Re: VA-23-00004 (Kosar Setback Variance Re-Notice)

Project Name (VA-23-0004) Kosar Setback Variance

**TO:** All Staff  
**FROM:** Public Works Plan Review Team  
**DATE:** August 4<sup>th</sup>, 2023  
**SUBJECT:** Public Works Comments: VA-23-00004 Kosar Re-Notice of Application

31 Eagle View Dr
Parcel 902134
7-10-23

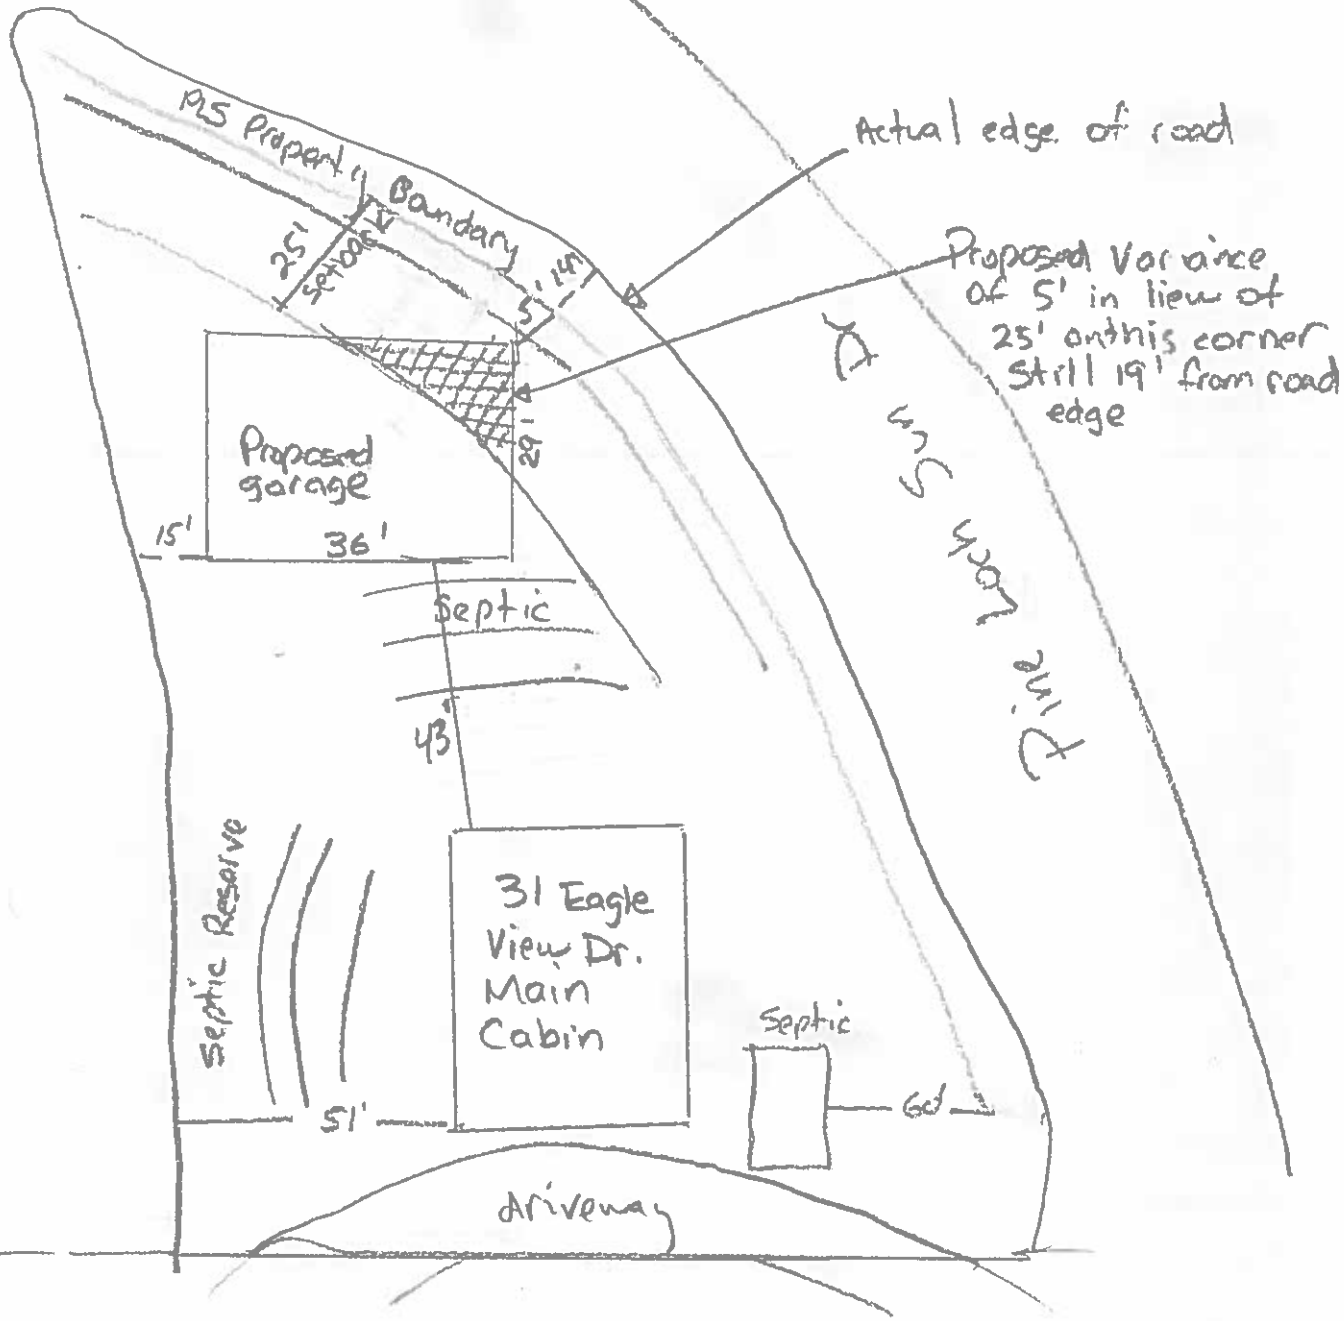
The Board of Pineloch Sun Beach Club would like to express our objection to the proposed setback variance. It is the position of the Association, that placing a building within 5 feet of the road boundary may negatively affect any future road improvements. Pineloch Sun Drive is the main road through Pineloch Sun, one of the busiest roads in PLS. While there are no clear plans for widening the roads at the present time, the membership has expressed interest in the future development of our roads. Having a permanent building within 5 feet of the property line will limit our options.

Pineloch Sun does not object to a 15-foot setback as originally proposed. We do, however, object to granting a variance to 5 feet.

<b>ACCESS</b>	No Comments (TM)
<b>ENGINEERING</b>	<ol style="list-style-type: none"><li>1. Previous comment was not addressed. Public Works is concerned that any excavation or fill required to build the garage may destabilize Pine Loch Sun Road. It is unclear from the Site Plan what the resulting slope will be. Please provide further information (proposed and existing) regarding the slope between the edge of road and the building pad. (CC)</li></ol>
<b>SURVEY</b>	<ol style="list-style-type: none"><li>1. Site plan provided does not make sense. 51' and 60' offsets shown for a parcel that is only 100' feet deep.</li><li>2. If approved, the building footprint and property boundaries shall be staked by a surveyor licensed within the state of Washington due to the tight tolerances proposed.</li><li>3. If approved, no part of the building (foundation, swinging doors, roof eaves) shall fall within the reduced setback area.</li></ol>
